From: Gregg, Robert <Robert.Gregg@lancashire.gov.uk>
Sent: 11 December 2020 17:16
To: Adam Birkett; Planning; LHS Customer Service
Subject: APP 3/2020/0911 - Shackletons Garden Centre Ltd Clitheroe Road Chatburn BB7 4JY

In respect to the proposed two-storey extension to rear and re-modelling of home and garden centre, including additional indoor and outdoor retail space and increased cafe area and play area, I have the following comments to make.

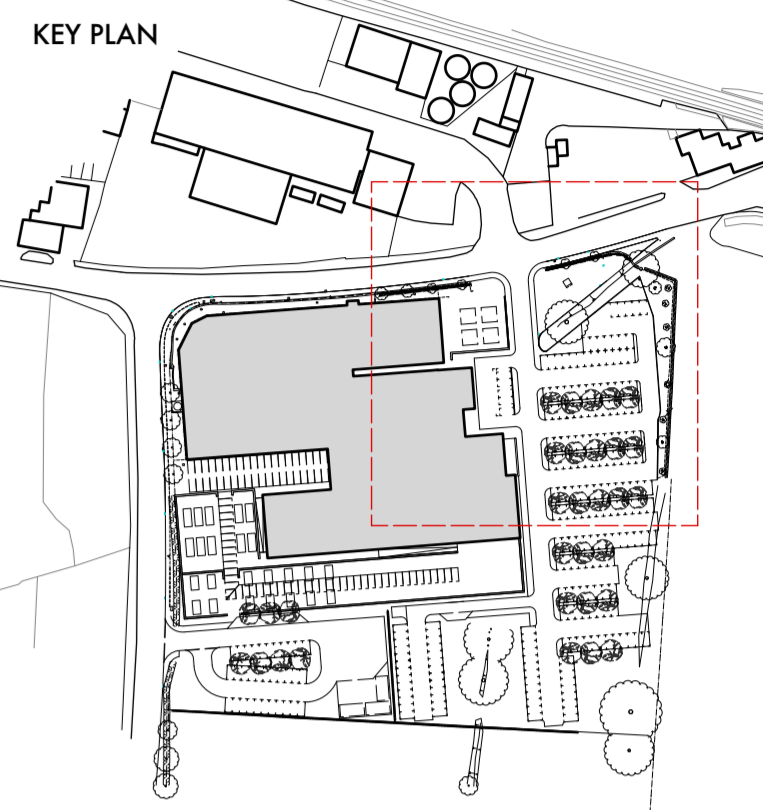
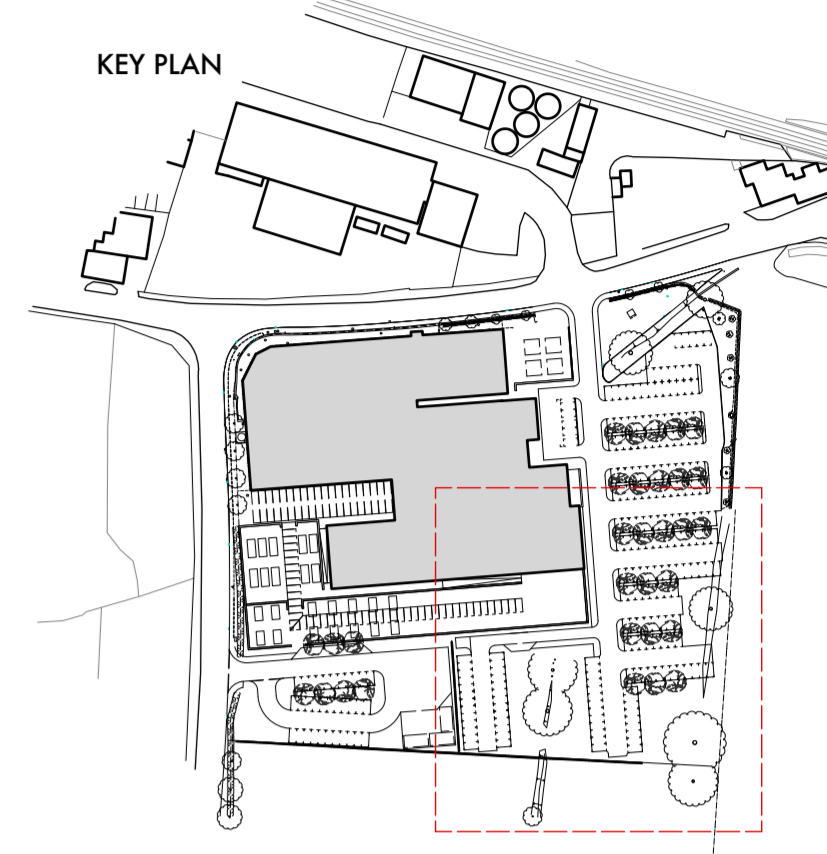
There will be an increase of 86 parking spaces, from 155 existing to a proposed 241 which include only 5 disabled bays and 36 cycle spaces.

5 disabled parking spaces would significantly fall lower than what is expected and therefore a minimum of 10 disabled parking spaces should be incorporated into the design layout, within close proximity of the main entrance to the building providing sufficient accessibility and manoeuvrability. 36 cycle space would be considered excessive and 20 cycle spaces would suffice, equally 10 motorcycle spaces should be provided and electric vehicle charging points should also be included.

There is are parking spaces that would not allow a 6m clearance to the rear and therefore would not be considered acceptable, equally vehicles being reserved out of there parking space should not enter any on-coming traffic. The 26 over-spill parking spaces would be accessed by a single track with a passing place, however the access track should support two-way traffic flows to ease congestion and should also have a barrier fence gating its access point to be opened as and when necessary in accordance with its intended purpose, the over-spill parking area should also have pedestrian access to and from the buildings main entrance point. So the design layout would need slightly adjusting.

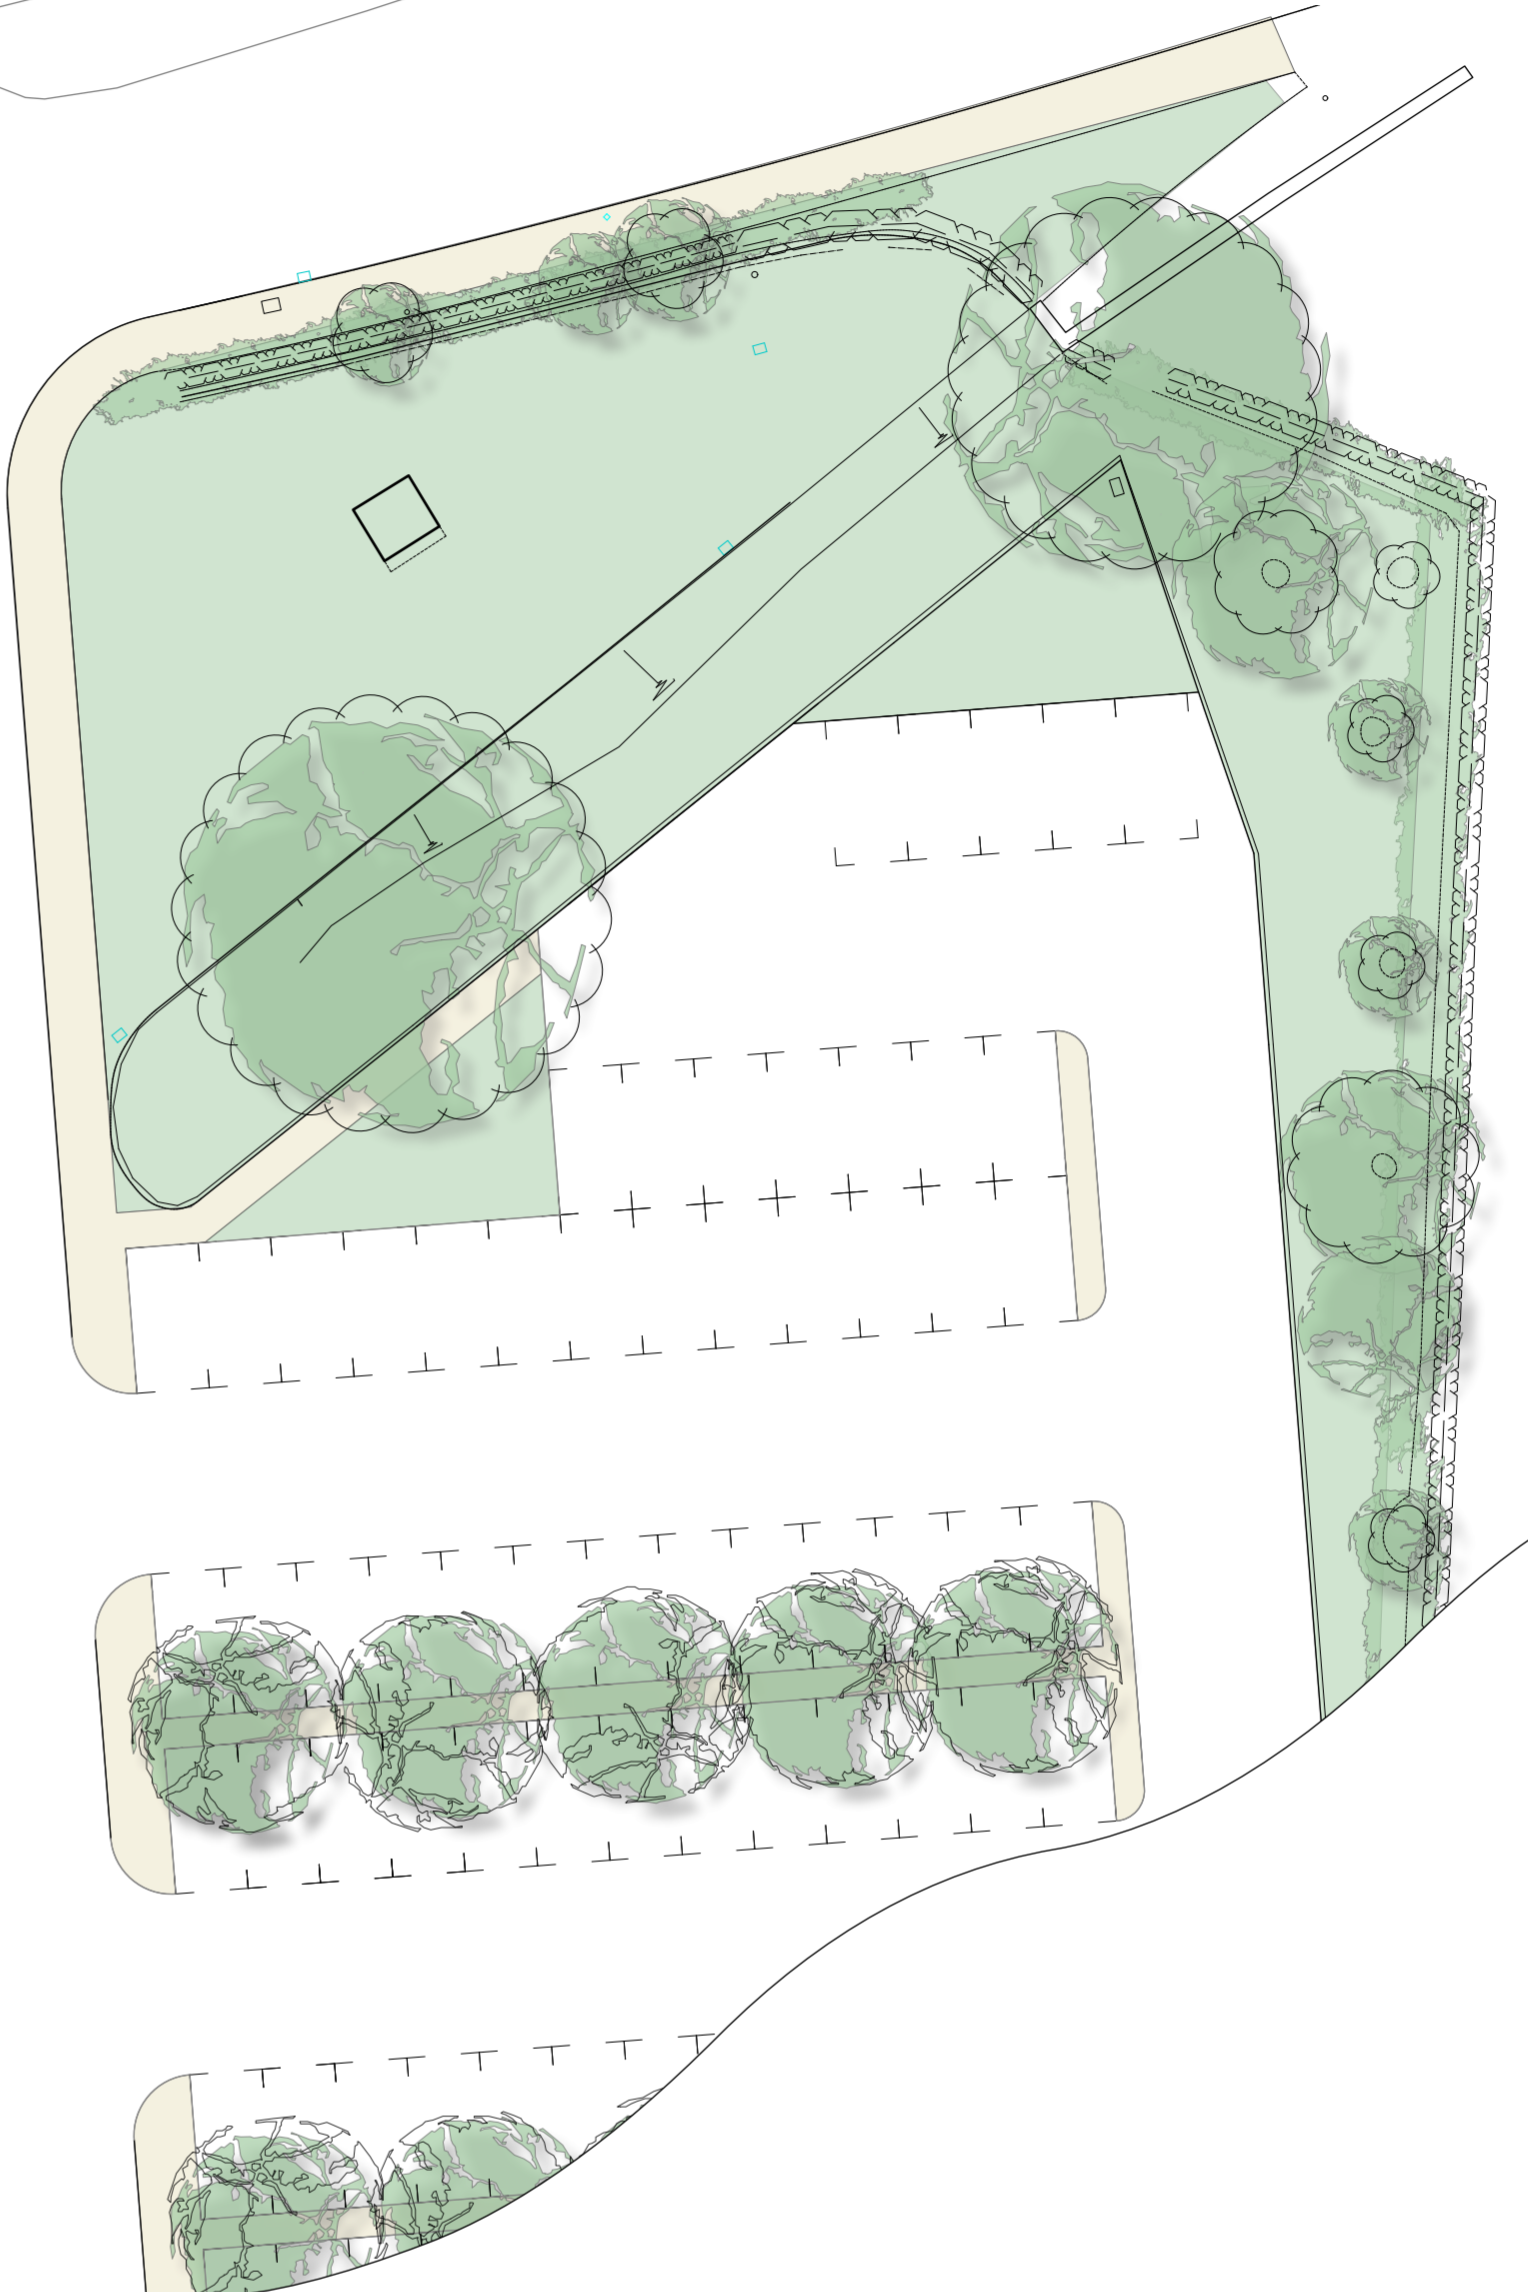
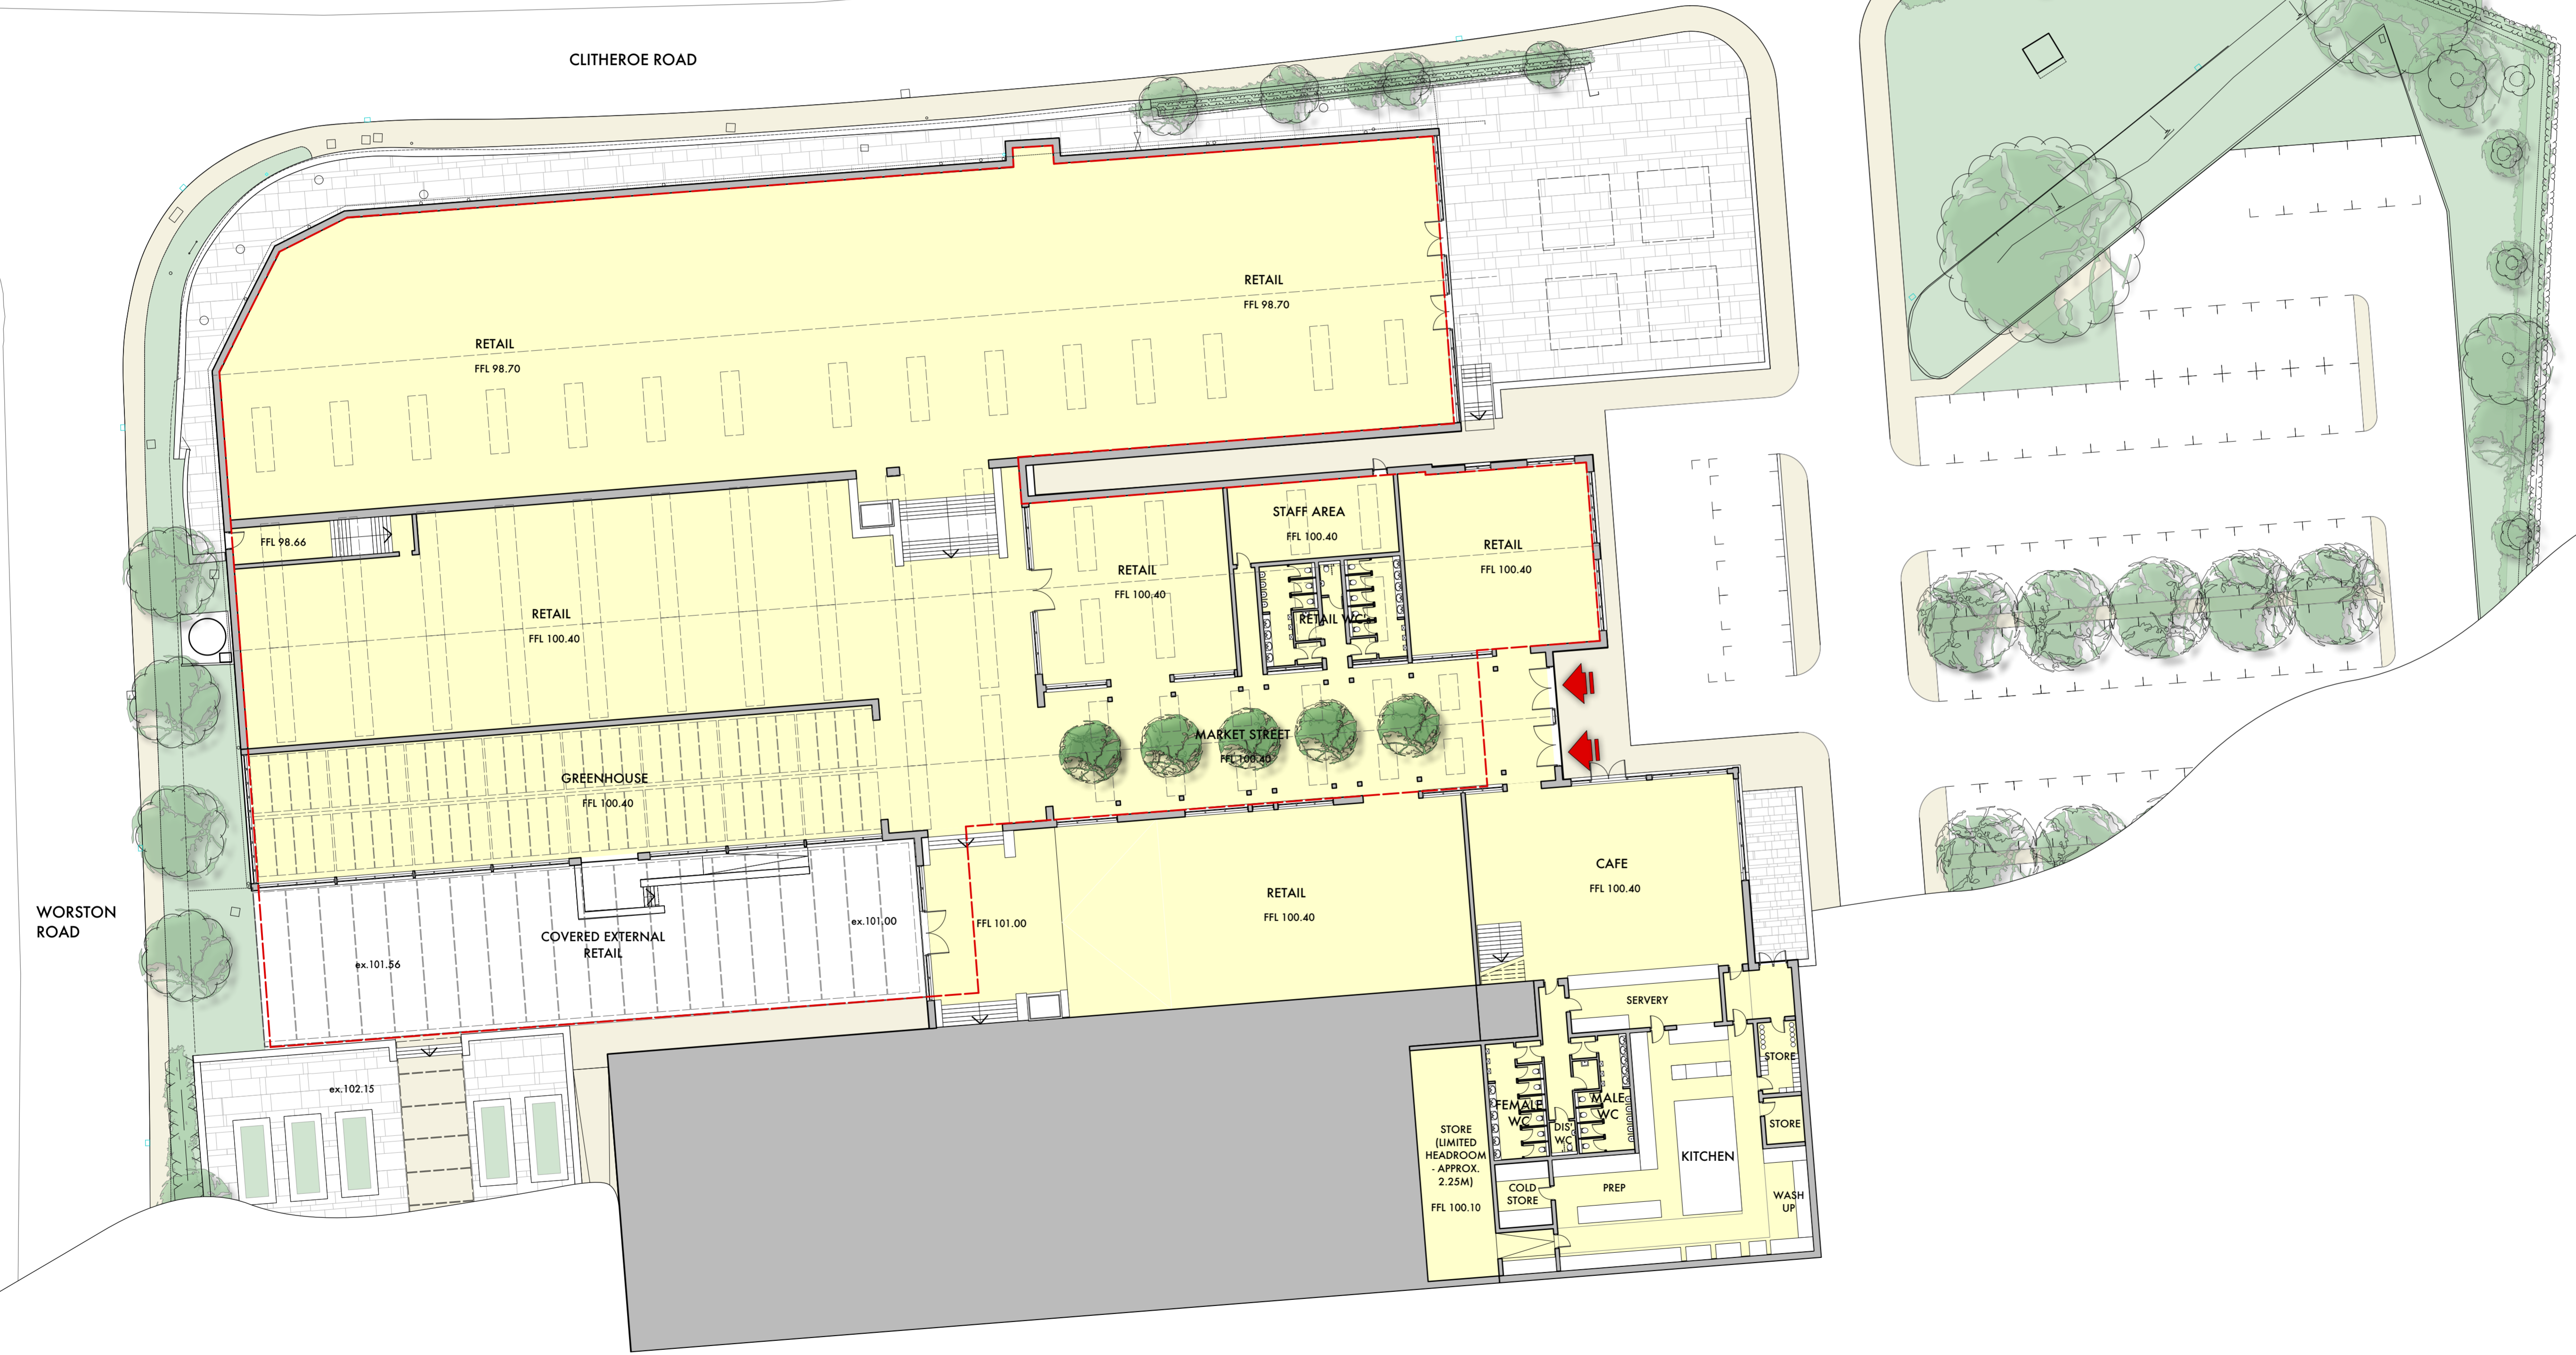
Visibility splays are required at both new entrance points which will obviously need to be constructed under Section 278 of the Highways Act 1980 and measures to intercept any surface water run-off from the site into the public highway in the form of an ACO drainage channel would need to be incorporated into the design.

The new entrance off Clitheroe Road should also be widened to allow 1x in lane and 2x out lanes *i.e.* 1 left turn out 1 right turn out. Thorough sweptpath analysis should also be provided to prove both of the access points and carparks safe accessibility.
